**Re: Unser/McMahon Mixed Use 10715 Unser Blvd. NW
Erosion and Sediment Control Plan
Engineer's Stamp Date 3/04/2021 (A11E017)**

Based upon the information provided in your submittal received 3/9/21, the above referenced ESC Plan can't be approved until the following comments are addressed.

ENGINEER'S SEAL	UNSER & McMAHON
		Unser Blvd & McMahon Blvd
		EROSION CONTROL PLAN
		SHEET #
		ECP-1
		JOB #
		2020015

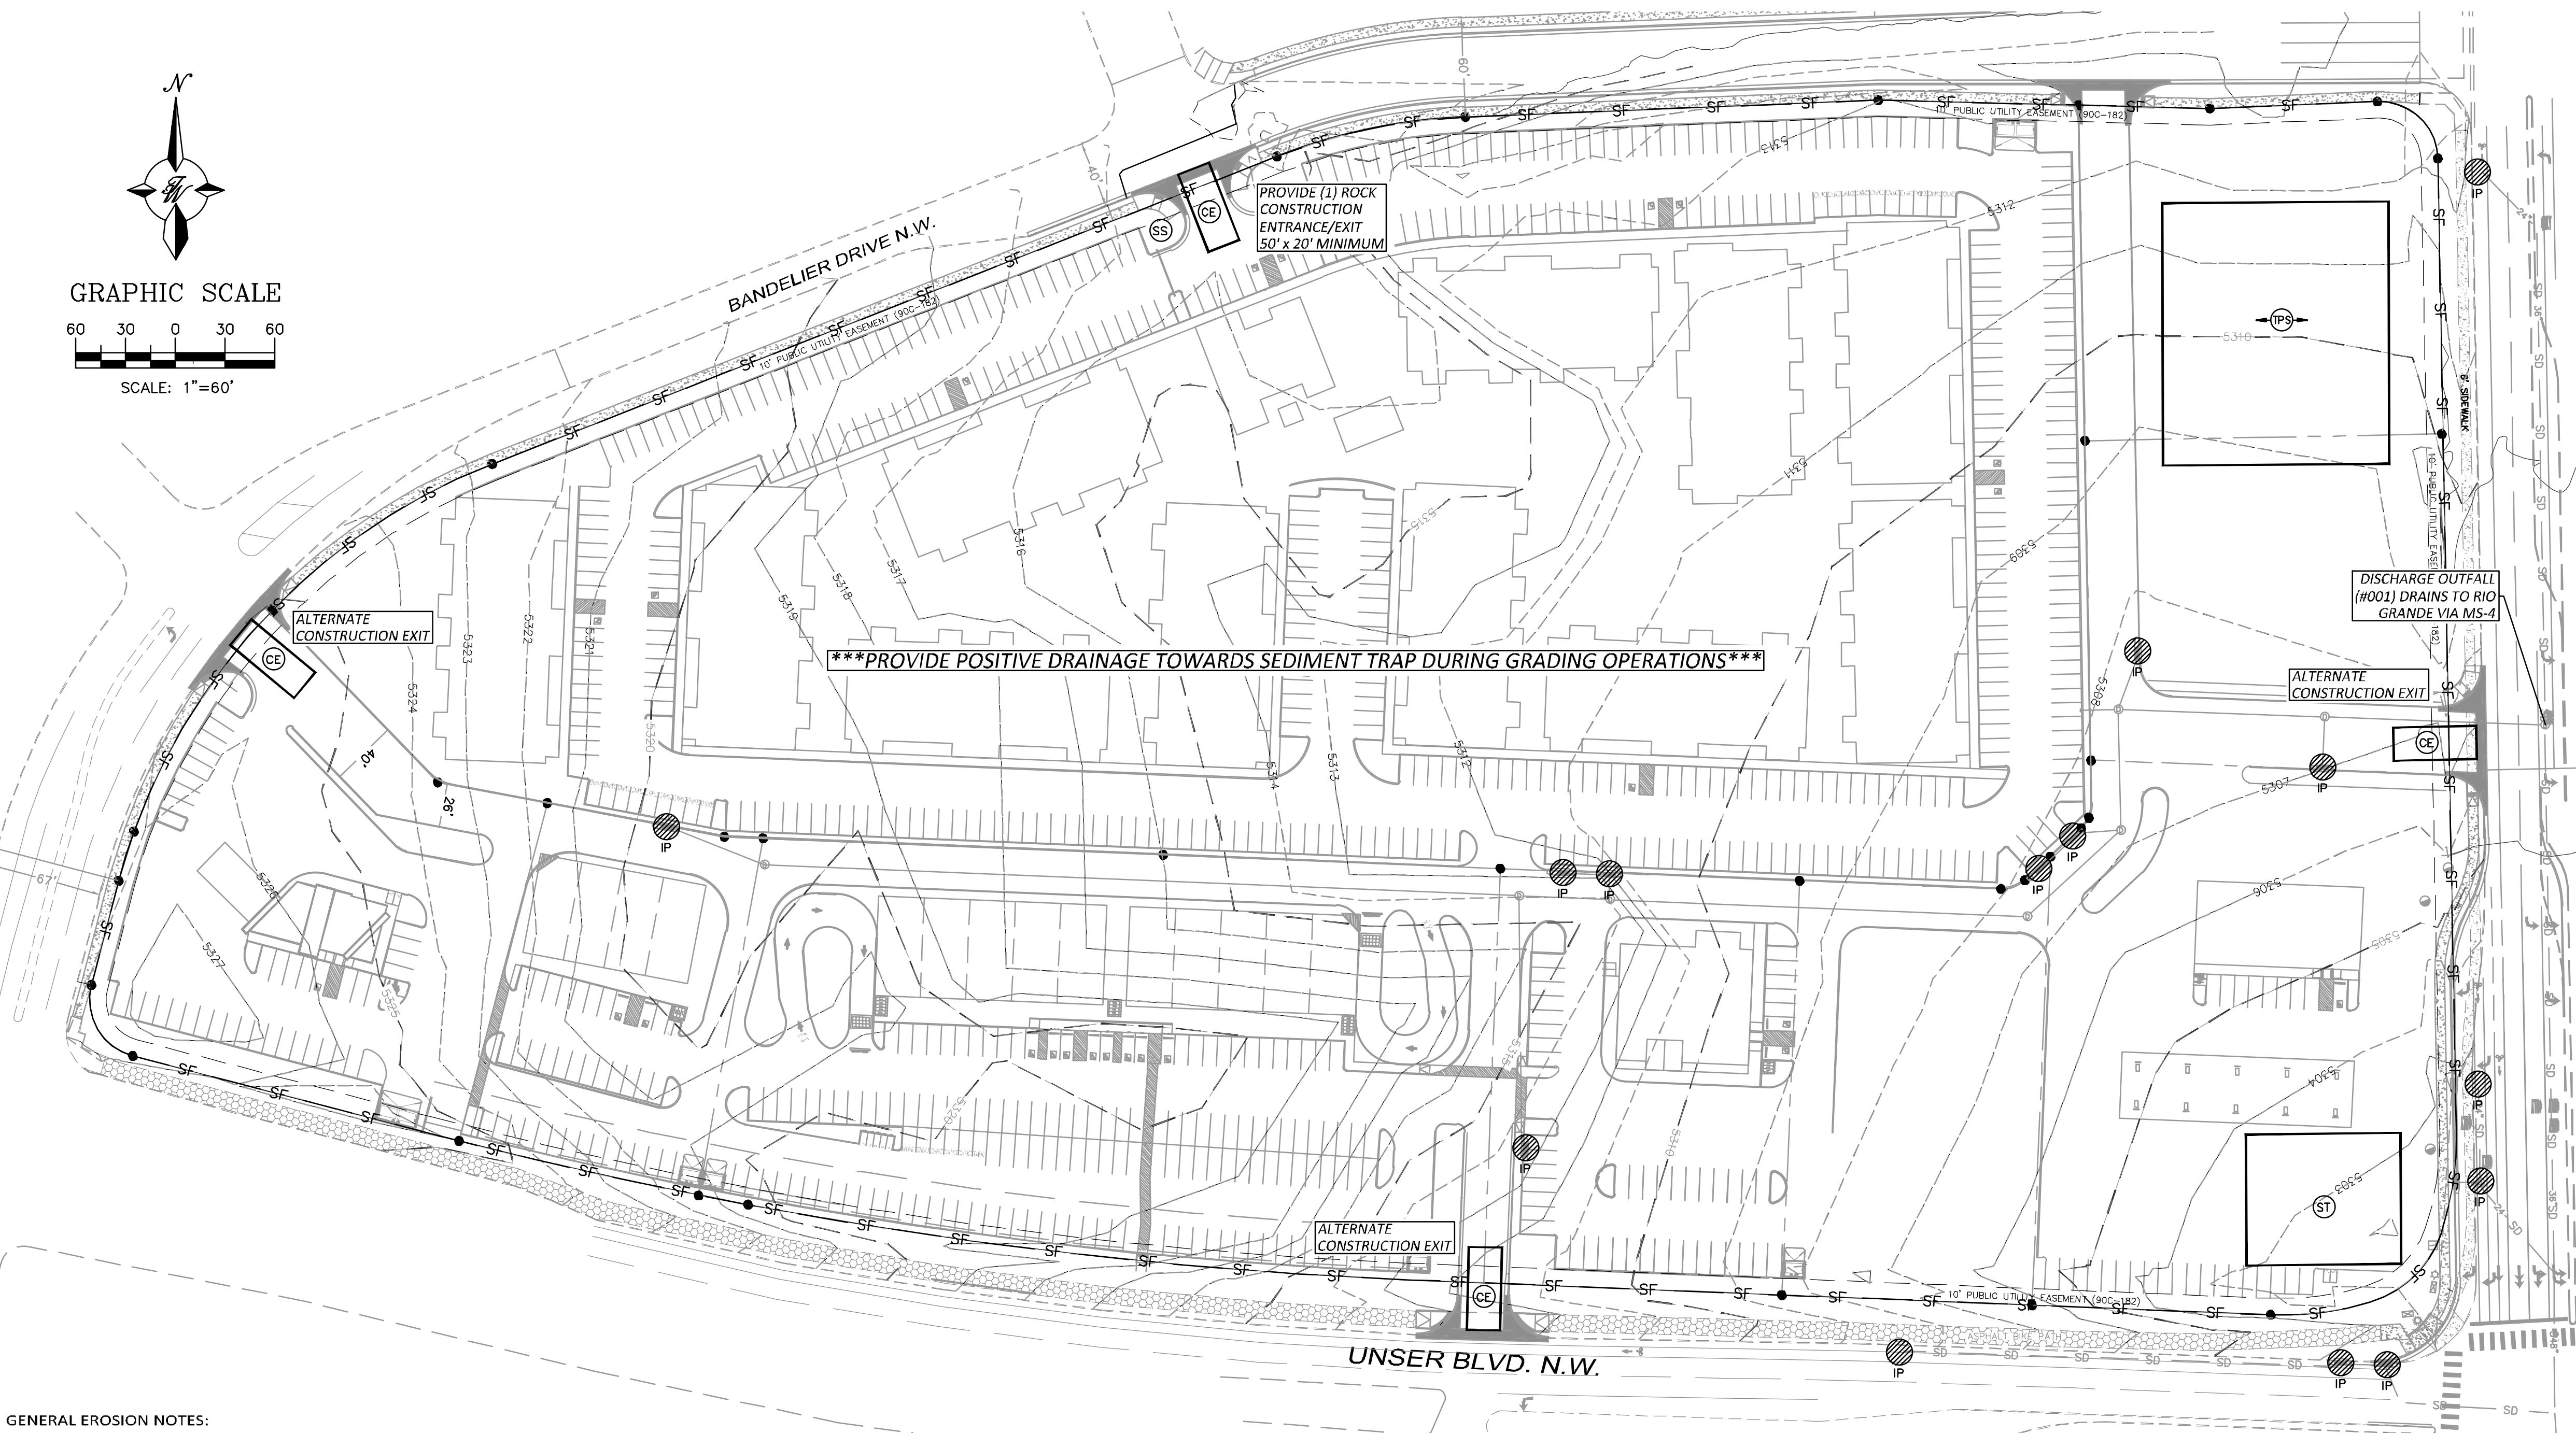
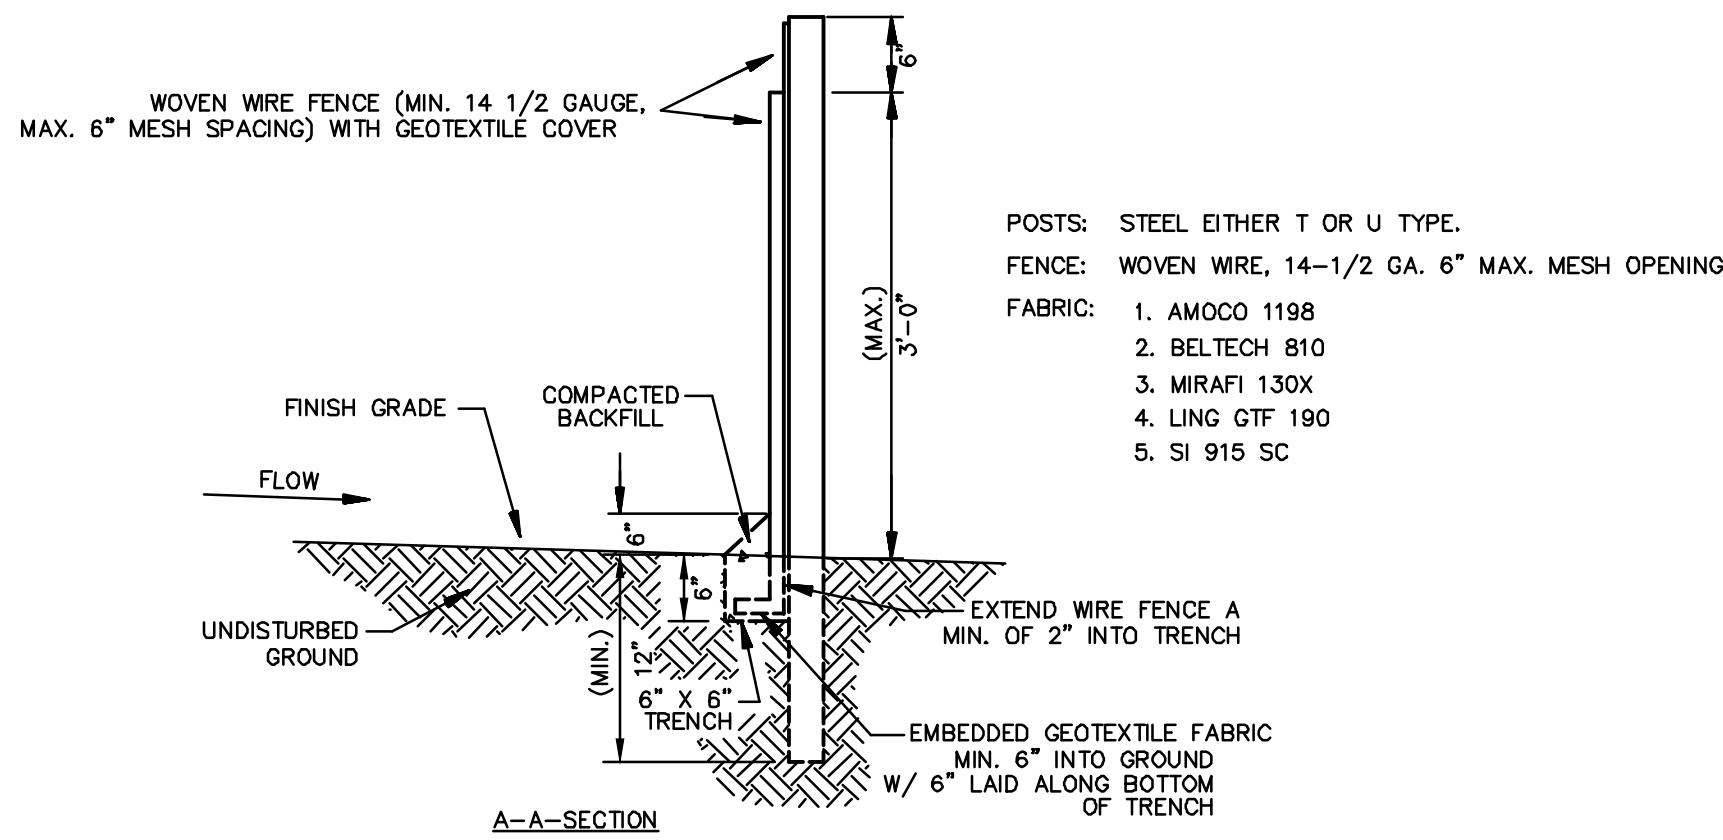
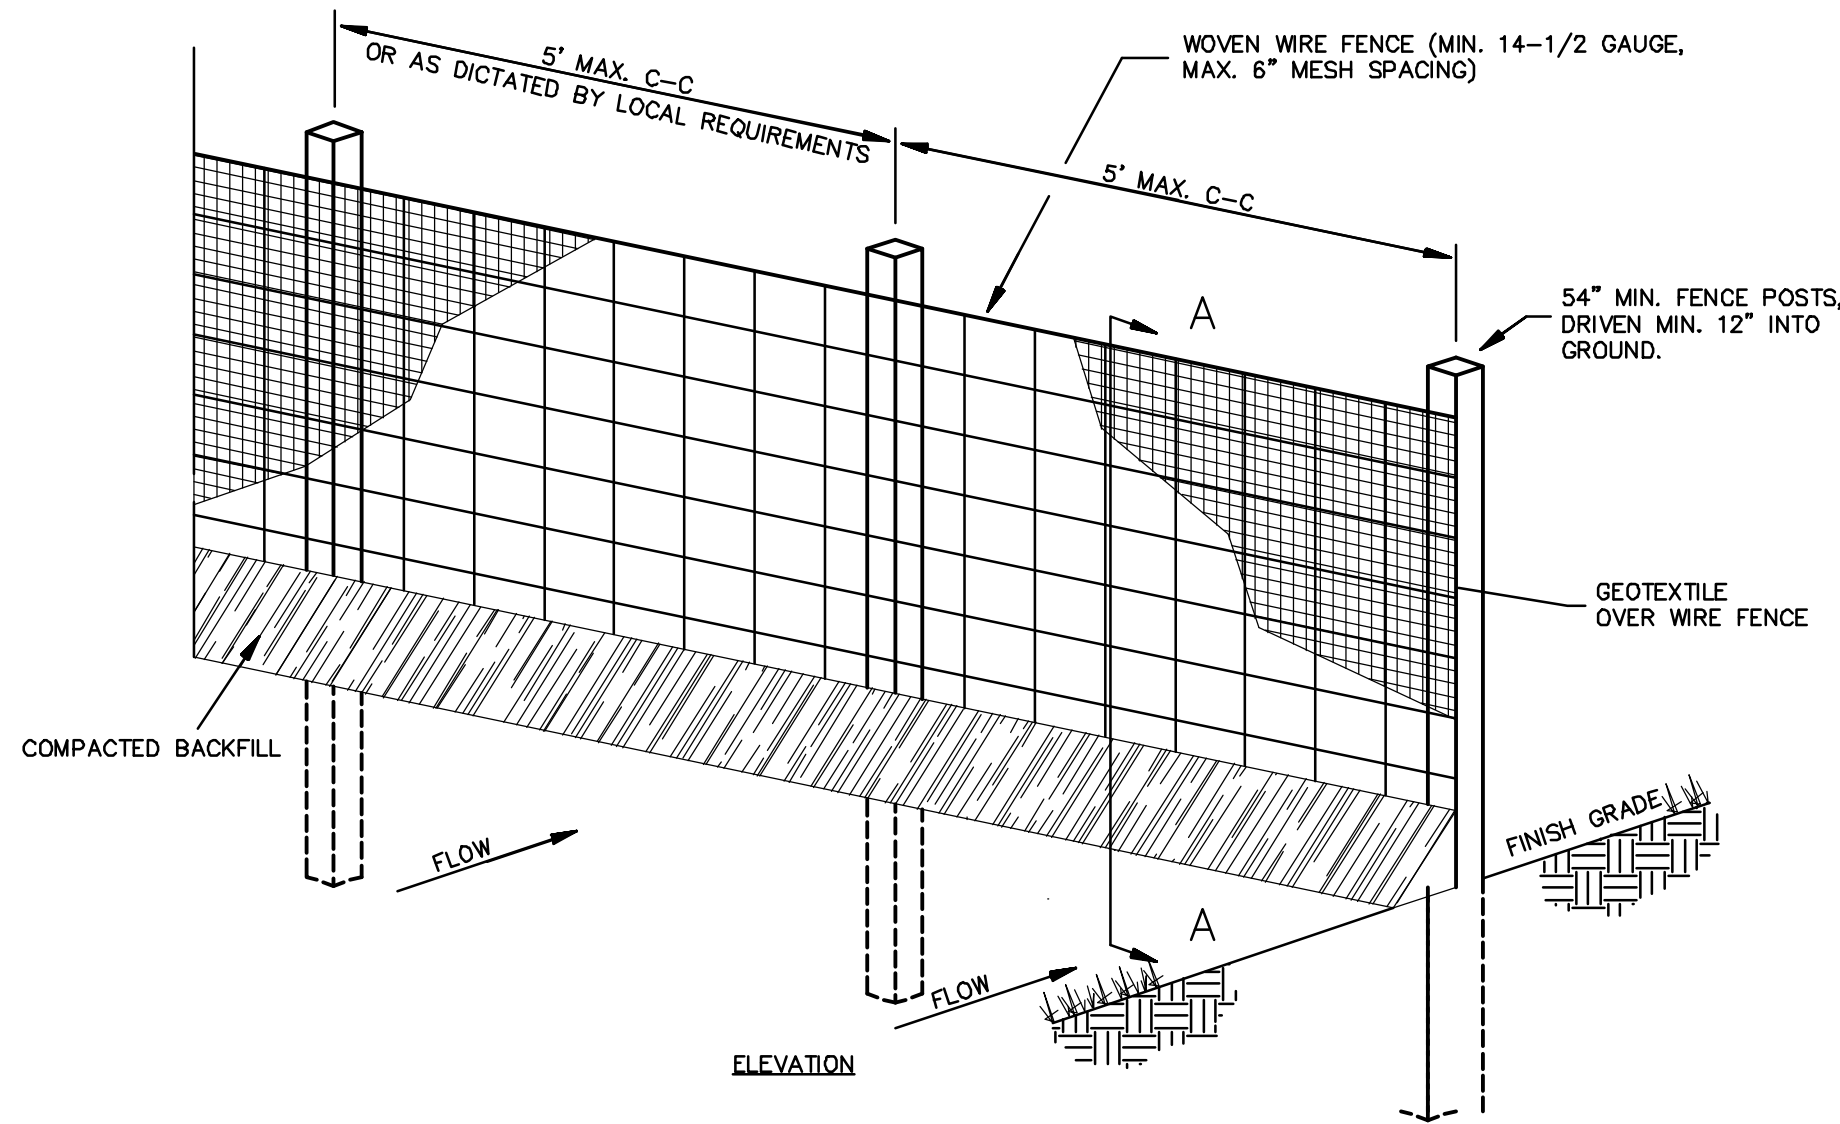
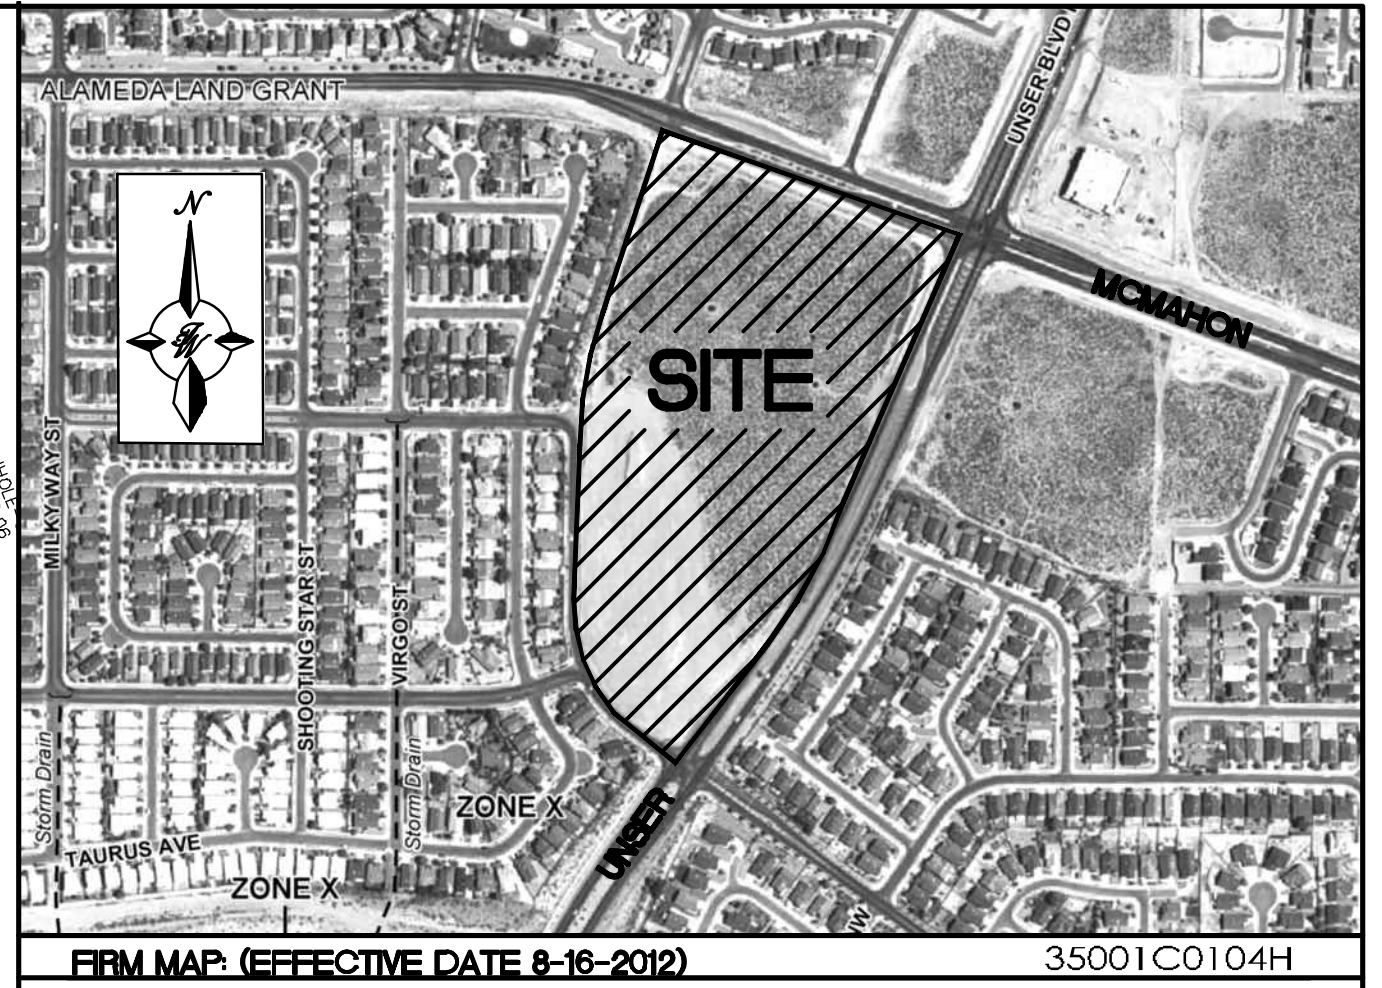
1. The North Arrow is pointing west;
2. The limits of disturbance must include all frontage improvements (CGP7.2.4.b.i);
3. The existing and proposed grades must be shown on the plan, and they must agree with the Grading Plan approved by Hydrology (CGP7.2.4.b.ii);

4. The locations of structures and other impervious surfaces. Differentiate between existing, construction this project, and future construction by others (CGP7.2.4.b.v);

5. Describe undisturbed and pre-construction ground cover (CGP7.2.4.e);
6. List operators on the plan, including name, phone #, and e-mail address. If unknown, leave blanks to be filled in later (CGP 7.2.1);

7. Identify stormwater team members responsible for sediment removal, mBMP maintenance, and inspections on the plan, including name, phone #, and e-mail address. If unknown, leave blanks to be filled in later (CGP 7.2.2);

8. Describe the nature and extent of construction activities (CGP 7.2.2.), including a) nature of construction activities, b) size of the property, c) size of disturbed area, d) description of construction support activities, e) size of maximum disturbed area, and f) Project Schedule. The three phases of this project are Grading, Infrastructure, and Sales. Provide a brief description of the nature of each phase. Include in the schedule the initial establishment of the sediment trap before the gradin phase, the removal of the sediment trap and placement of additional silt fence to keep sediment out of the onsite street after the infrastructure phase, and the annual maintenance plan of the BMPs and stabilization practices (temporary and permanent) during the sales phase. Describe the expected circumstances of Termination of permit coverage including a final stabilization specification or sale and transfer to other operators. The operators and team members for each phase should be identified in 6 and 7 above.

9. Stabilization measures (CGP 7.2.6.b.vi), including a) **Specific** vegetative and nonvegetative practices, b) deadlines, c) beginning and ending dates of the seasonably dry period, d) procedure to comply with The Weed Removal Ordinance (§ 9-8-1) during sales phase.

10. Soil information – add a table with name type, particle sizes, and Erodibility factor (CGP 2.1.1).
11. Update the engineer's stamp date each time the plan is changed.
12. Vicinity map – add a zone atlas map clearly indicating location and street names.
13. City Standard ESC Notes attached.
14. The ESC Plan can't be approved for Grading or Work Order until the property owner's NOI has been reviewed and approved by City Stormwater Quality.
